Consultation Response from Highways England		
2020/91889 Former North Bierley Waste Water Treatment Works, Oakenshaw, BD12 7ET		
Discharge condition 20 on previous permission 2016/92298 for outline application for re-development of former waste water treatment works following demolition of existing structures to provide employment uses (use classes B1(c), B2 and B8)		
Date Responded: 15th July 2020	Responding Officer: Paula Bedford	Responding Ref: HEPR16

Highways England Planning Response (HEPR 16-01)

Council's Reference: 2020/91889

No. 60221630					Rev: 5

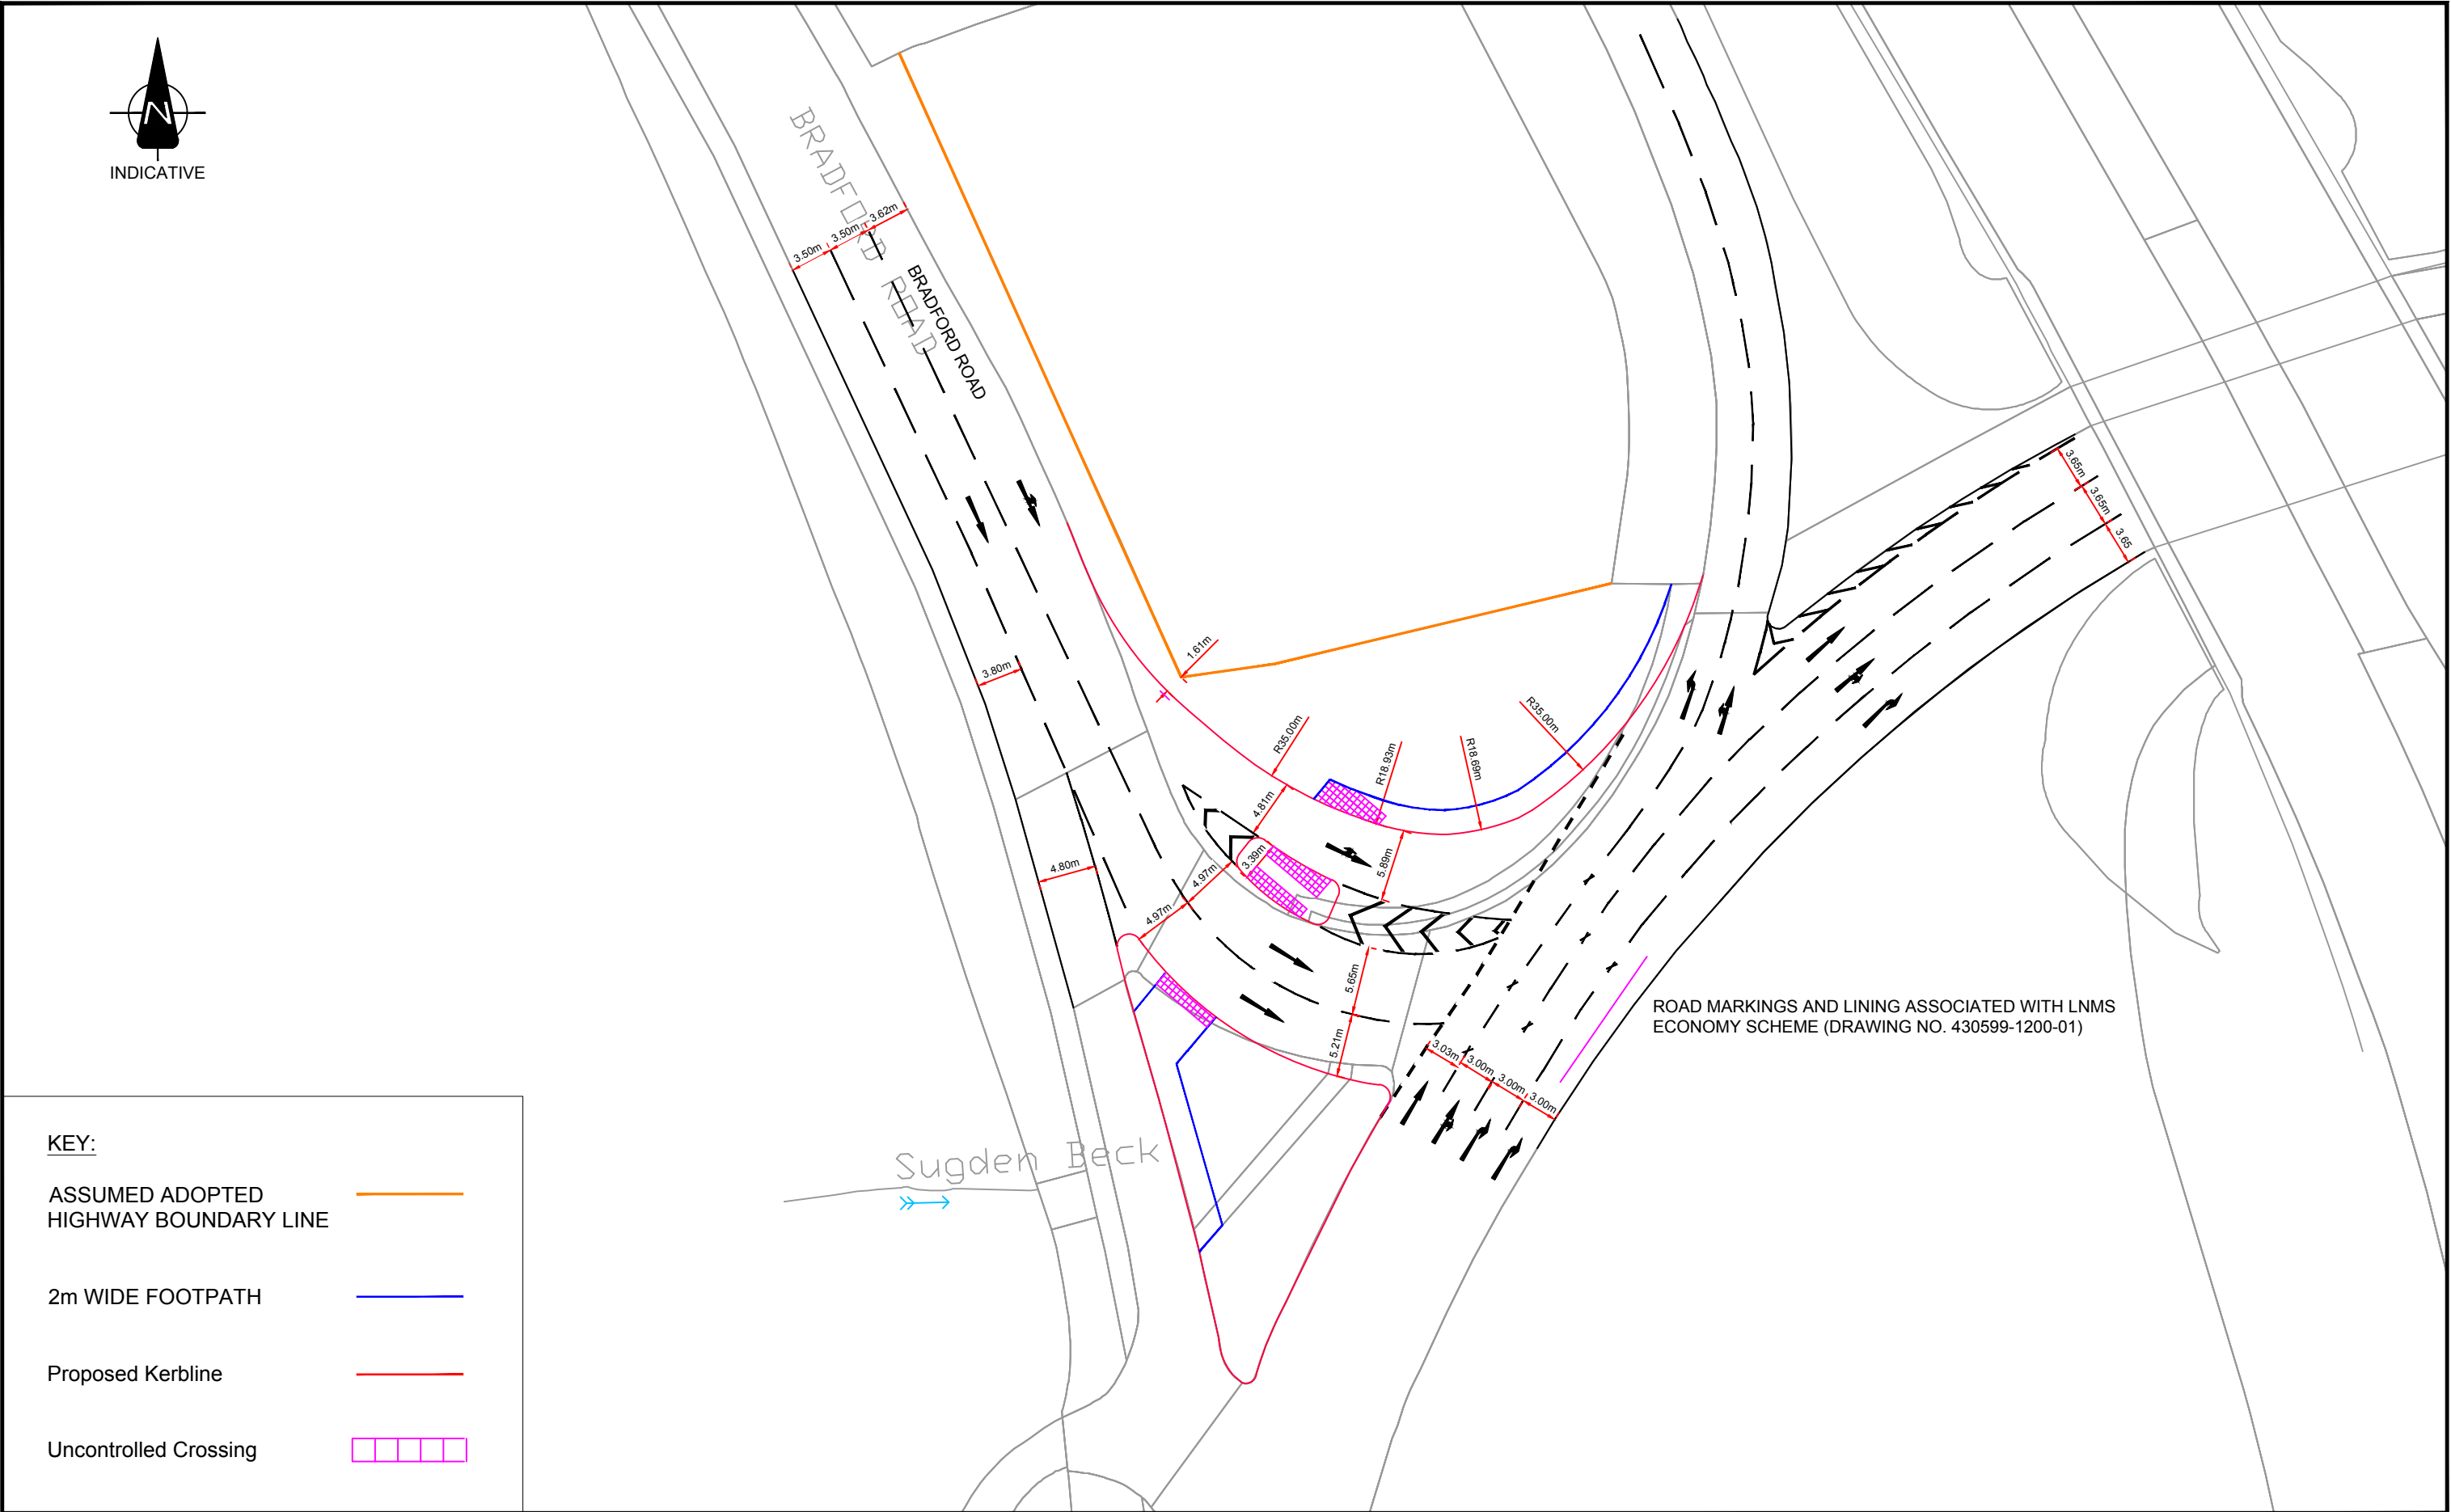
Whilst Highways England accepted the principle of the proposed works outlined in drawing 60221630 Rev 5 we have yet agree the detailed design for the improvement scheme which must also be subject to a Stage 2 Road Safety Audit before we can formally agree that condition 20 being discharged.

We will work with the applicant and Kirklees Highways Department to progress this however until these matters are satisfactorily concluded Highways England recommends that planning consent should not be granted in order to ensure the safe and continued operation of the SRN.
